84 Annandale Avenue
Bognor Regis
PO21 2EX
10th April 2018

Reference - BR / 42 / 18 / PL (Planning Application 86 Annandale Avenue)

DRAWING
PROPOSED PLANS
DRAWING No
247/04
SCALE 1:100
DATE PER 2019
REVISION
DRAWN
CHECKED
LA

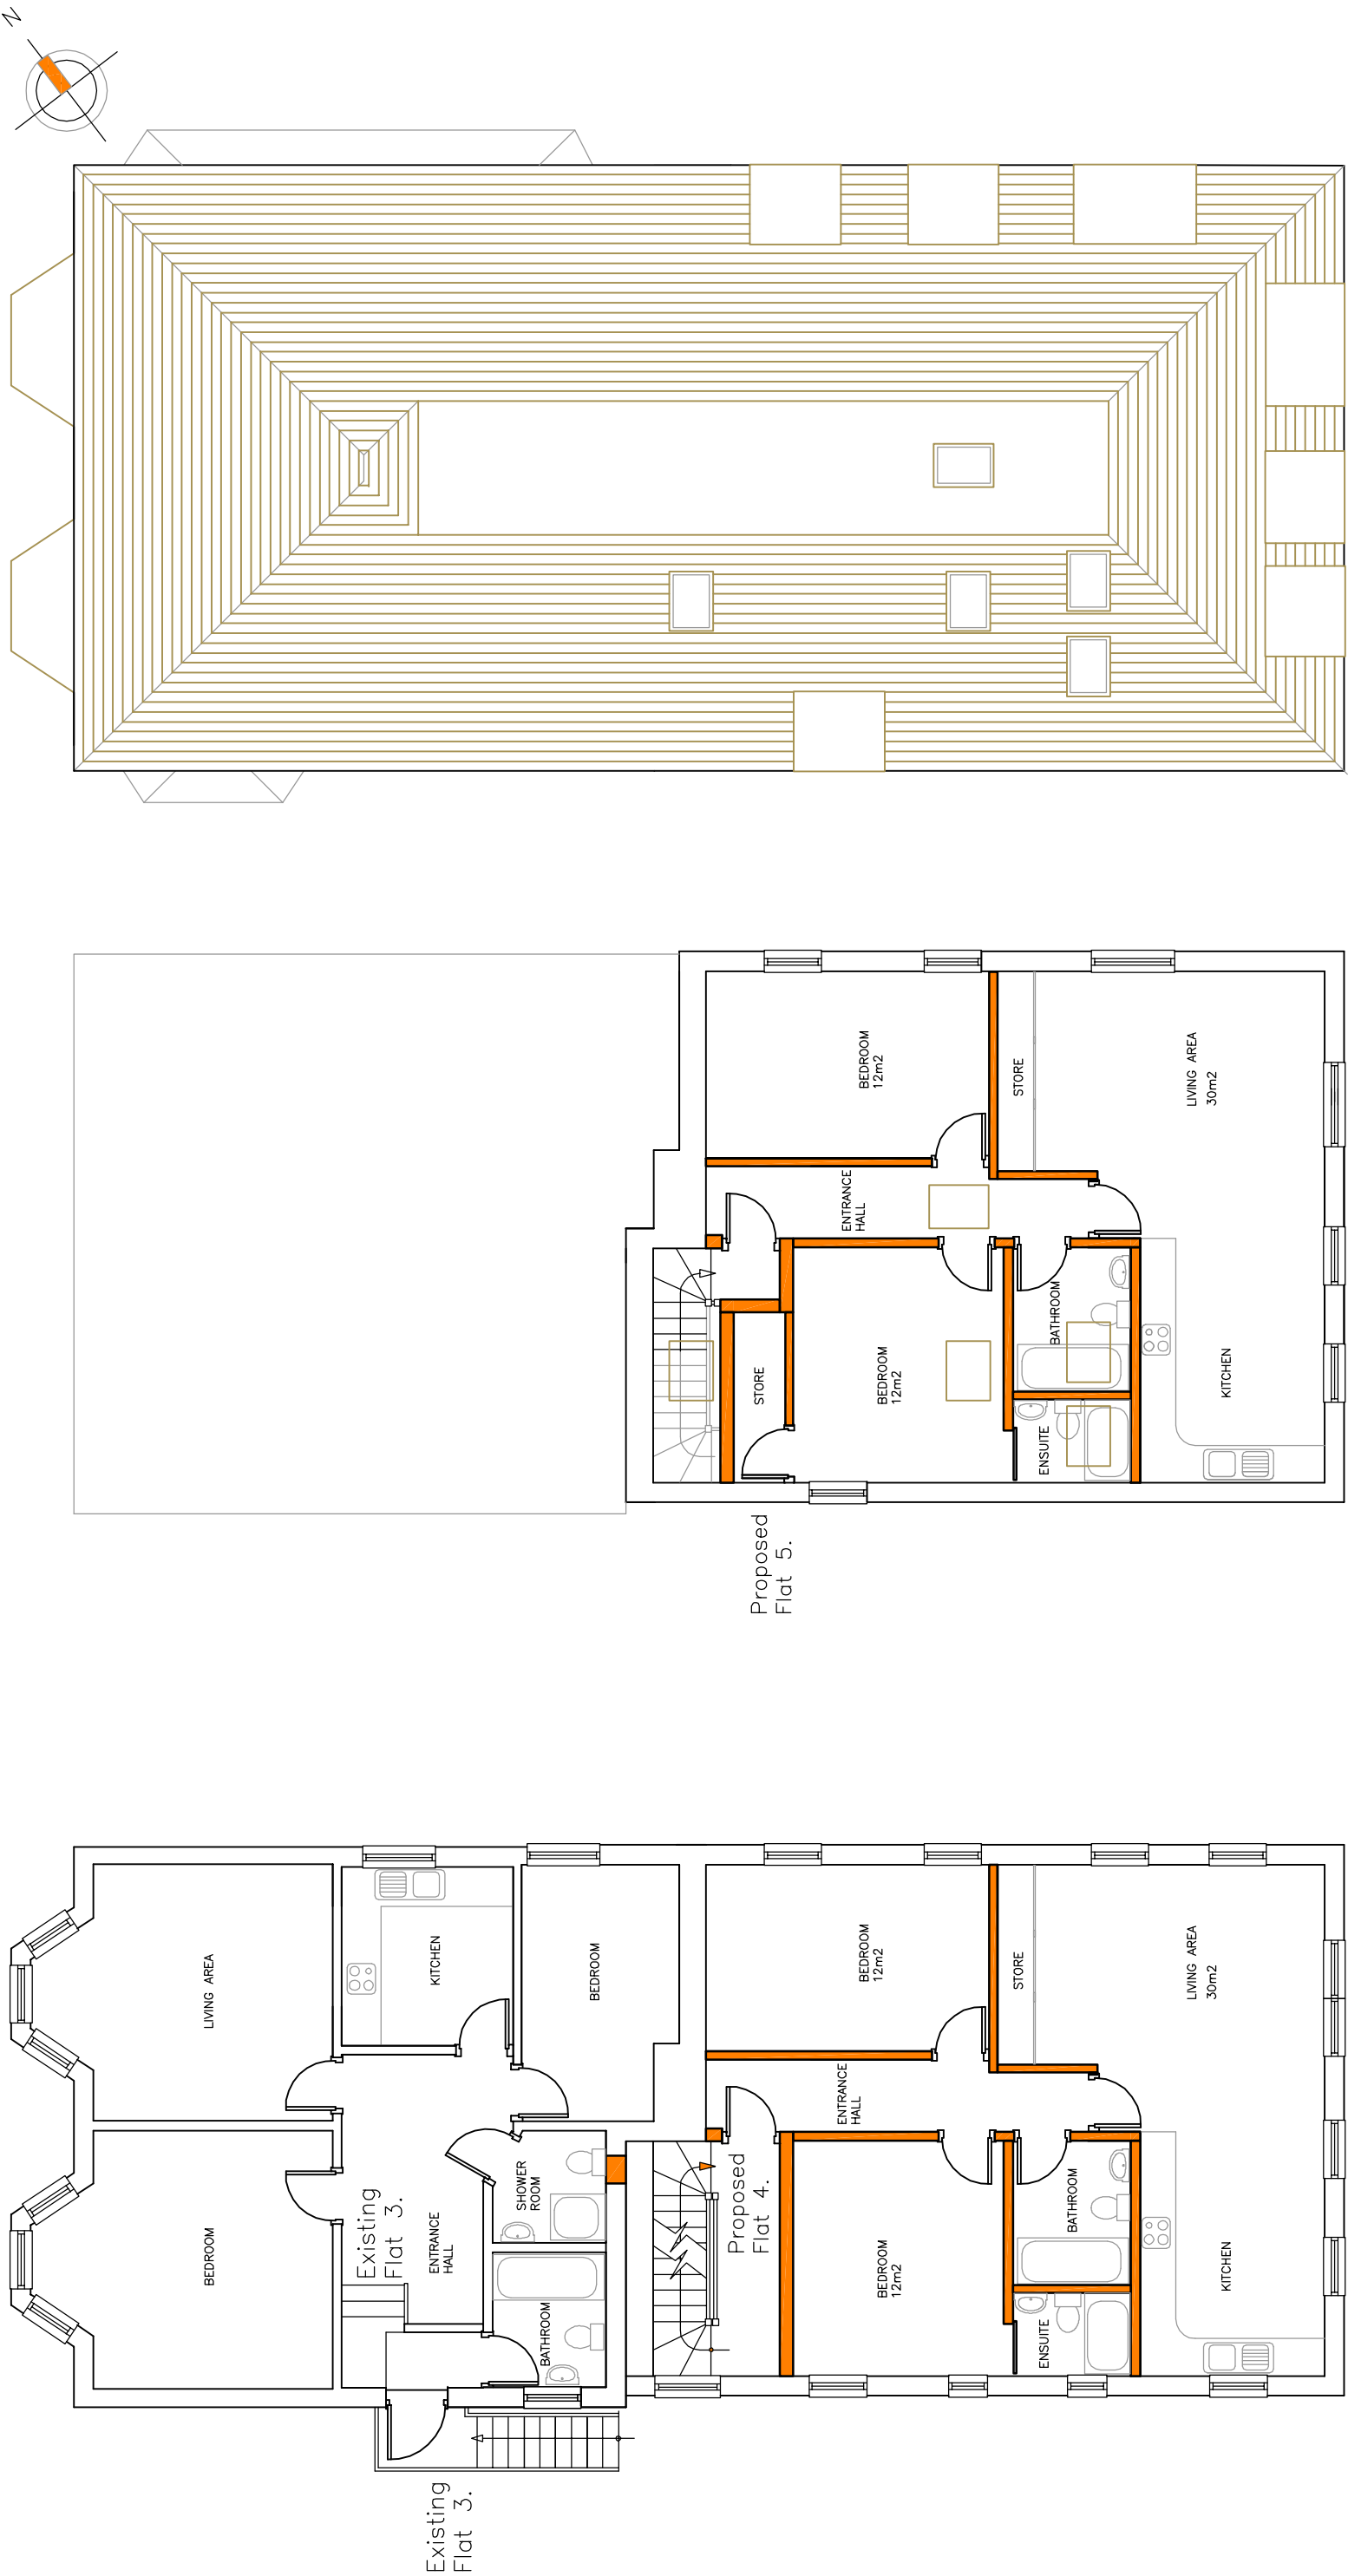
I thought there was a law that does not allow one dwelling to be so close that they can look directly into another residents house and garden and therefore deny those people their privacy.

How is it that whoever drew up the plans for the development of 86 Annandale Avenue proposes to flout this law with possibly ten windows overlooking some of 84's rooms and the entire garden and of course because of the height of the building there will be a loss of light.
